My Ref: D1755AIAL1

29th August 2017

**RE: AW/155/17/PL - BRUS LODGE, 28A KINGSWAY, ALDWICK, PO21 4DH
PROPOSED DEVELOPMENT**

Tree Retention and Protection Plan

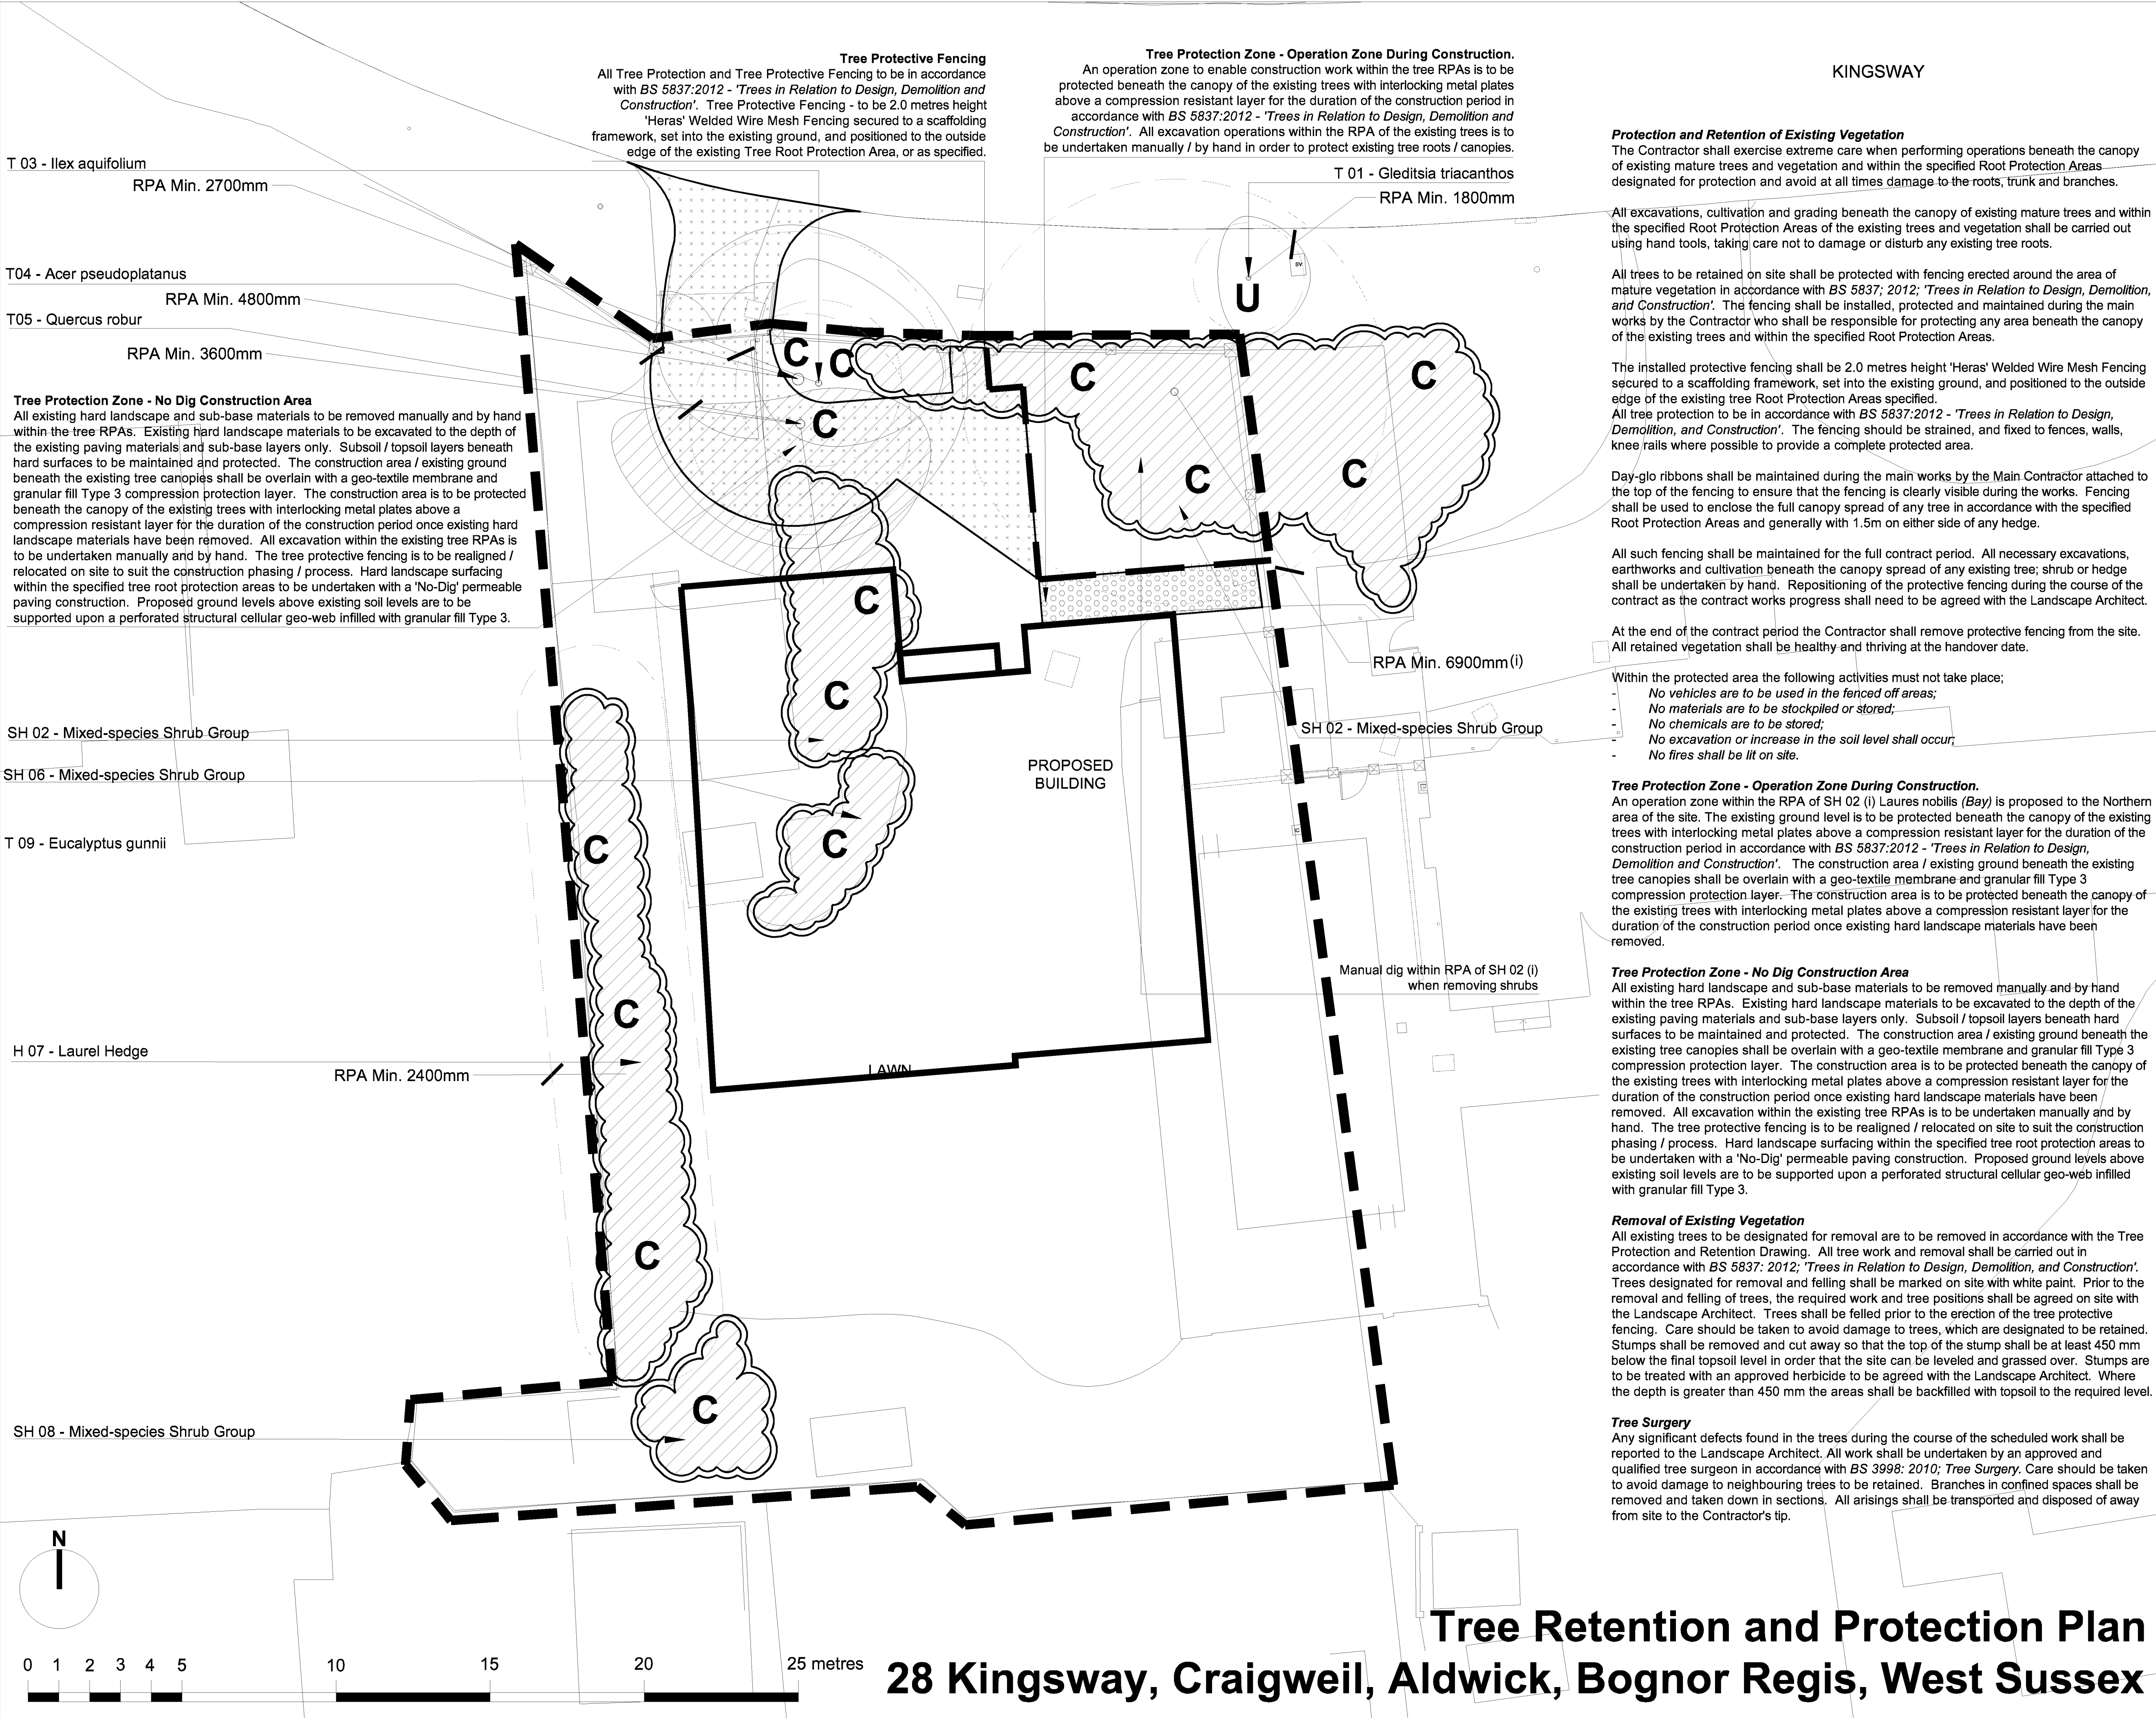
Tree constraints plan: This is prepared by Lizard Landscape Design and based on the Seaman Partnership Ltd tree schedule and in turn informs the Lizard Landscape Design Tree Retention and Protection Plan. Both plans are challenging to read, requiring reference to the tree schedule

for detail corroboration. The Tree Retention plan is optimistic in its management of the proposed surfacing in relation to the retained T4 (which appears to be a Norway maple); and the proposed protective fencing does not give sufficient and practicable room for building construction access across the front elevation of the proposed building. No protection is shown for T4. Generally, I take the view that protection measures should be in proportion to the health, condition and amenity value of the trees. I find that the trees and vegetation on this site frontage show evidence of haphazard pruning and benign neglect which significantly affects their health, form and long-term prospects. From the road, the vegetation looks healthy; closer inspection shows structural, management and health problems. However, this does not mean that whatever elements are to be retained do not warrant proper protection, and in that respect, I find that the tree protection and site management proposals are not adequate. This is partly due to the odd arrangement of the access round the Norway maple; and it is not clear by what assessment method it was determined that the oak should go and the Norway maple remain, as both trees are similar in condition and form. I am not satisfied that the submitted Tree Retention and Protection Plan and method statement are confidently clear or reasonably practicable and adequately address the issue of harm to retained trees. Nor am I satisfied that a condition of consent requiring a revised protection plan and method statement would be a sufficient improvement as to remove the concerns about harm to trees. BS5837 recommends that tree information should be used to inform proposed layouts and design. I have seen no evidence in these submissions to suggest that this approach was taken here; the evidence I have seen suggests that a layout was determined, and the tree decisions came afterwards
